Memo

To: Doug Brown/
From: Mike Nugent/Manager of Inspection Services
CC: Sam Hoffses/Building Inspector
Date: 07/19/01
Re: Grade adjacent to above ground pools

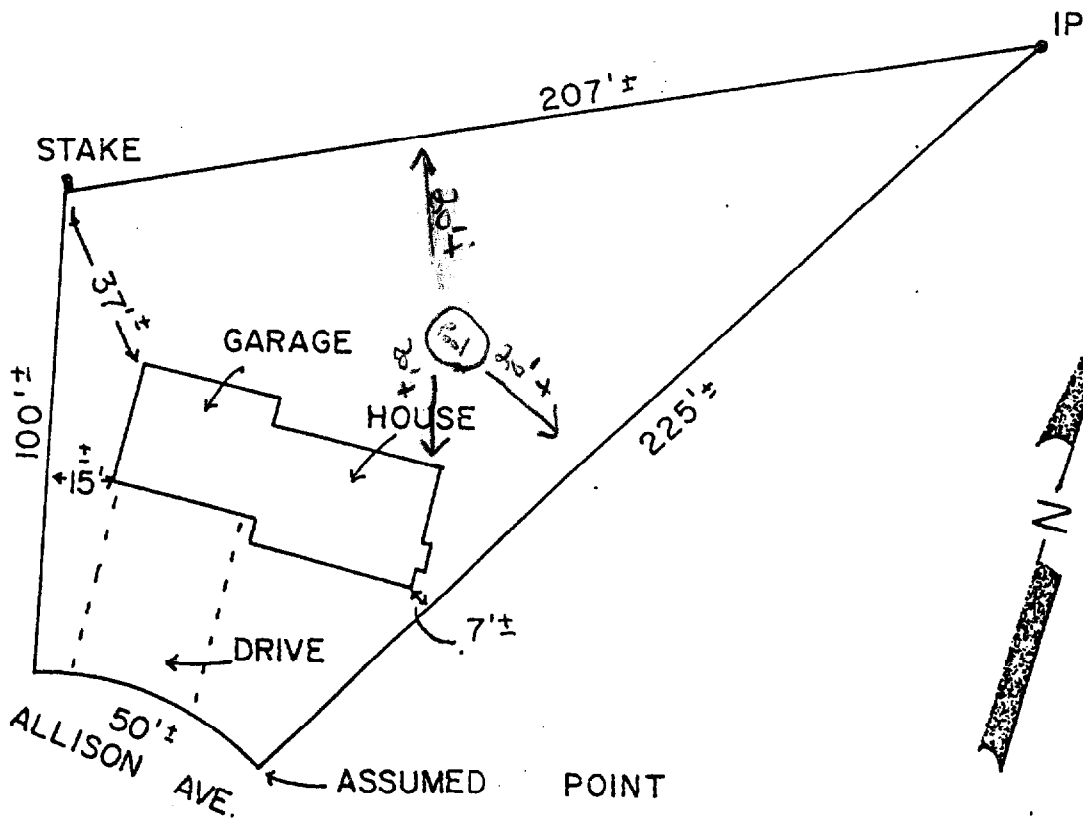
This office has reviewed your request for grading for the above installation, and find that 2 feet of net area is not sufficient to provide a barrier of 48" as required by Code. After consulting BOCA (code author) and meeting with Sam Hoffses, Building Inspector, our position is that a 3 foot wide net area before any grade change would provide adequate protection as required by the Code. Please feel free to call me at 874-8700.
